breakfast point residents group

MP 07-0006 – KENDALL BAY MARINA

**OPPOSING SUBMISSION LODGED BY THE BREAKFAST POINT RESIDENTS GROUP INC. TO MP07-0006
November 2010**

Design	Scales	Job No.	01013
Drawn	1:1000	Dwg. No.	SK15
App'd.	Date 27.10.06	Rev. No.	B
	Sheet Size B1

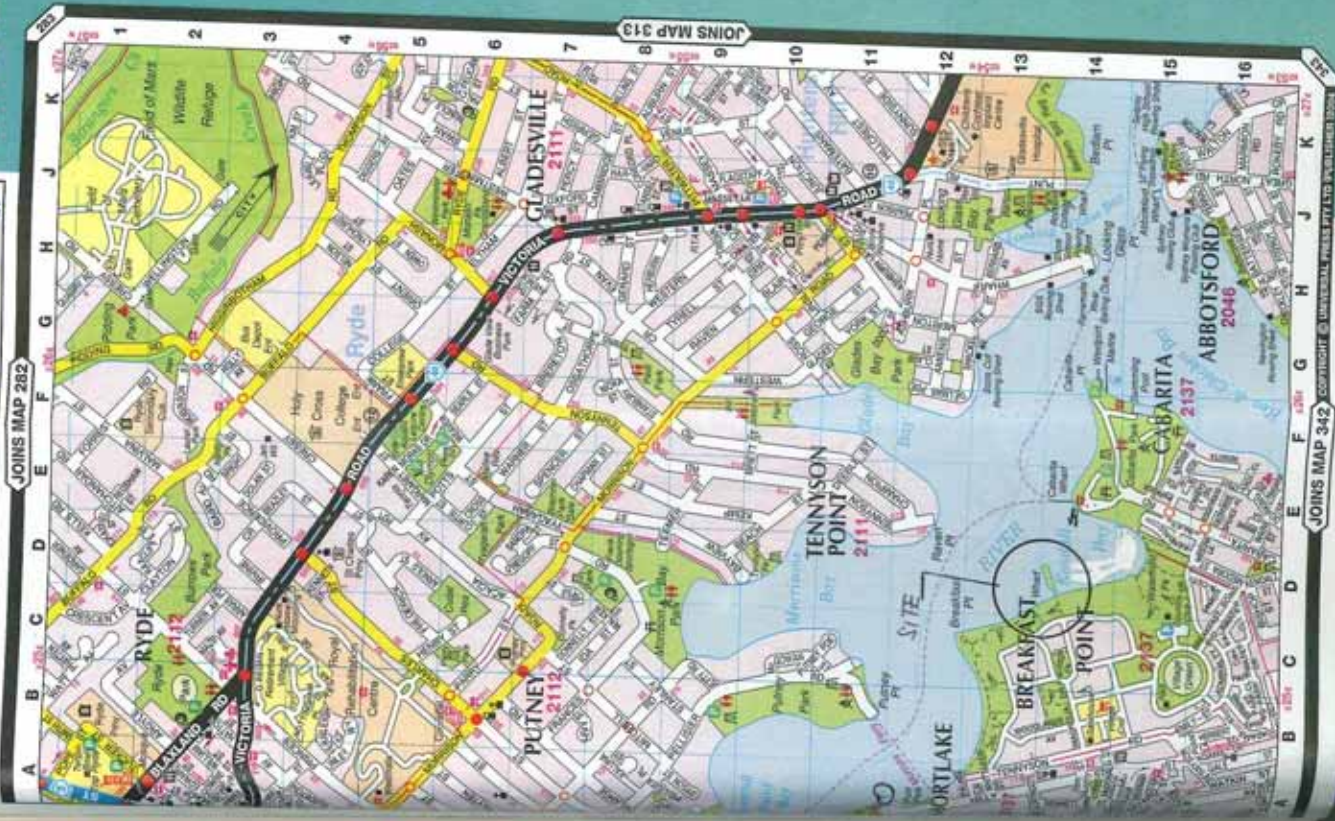
Notwithstanding the misdescription NSW Maritime gave its consent on 3 July 2008. This approval was given on the basis of a drawing/plan that is different to the one lodged with *the MPA* on 18 April, 2007 even though, as on the original, it is identified as “SK15B” rather than as “Amended SK15B” or by some other appropriate description.

As just mentioned the consent from NSW Maritime was based on drawing SK15B and on two other plans that did not form part of the documents lodged with *the MPA* of 18 April, 2007 or, to be more precise, that are not displayed as part of *the MAP* on the DoP web site. This is a worry. What happened to governance and transparency? What other documents, not on the DoP web site, were submitted to NSW Maritime or to DoP or both that have not been disclosed?

Drawing SK15B depicts a marina *mostly* adjacent to the Breakfast Point residential development¹ but also on part of the development itself and shows the proposed marina as making use of facilities, the ownership of which is in the hands of the Community Association DP No 270347 (*the Community Association*)² and not the applicant to *the MPA*. More on this later³.
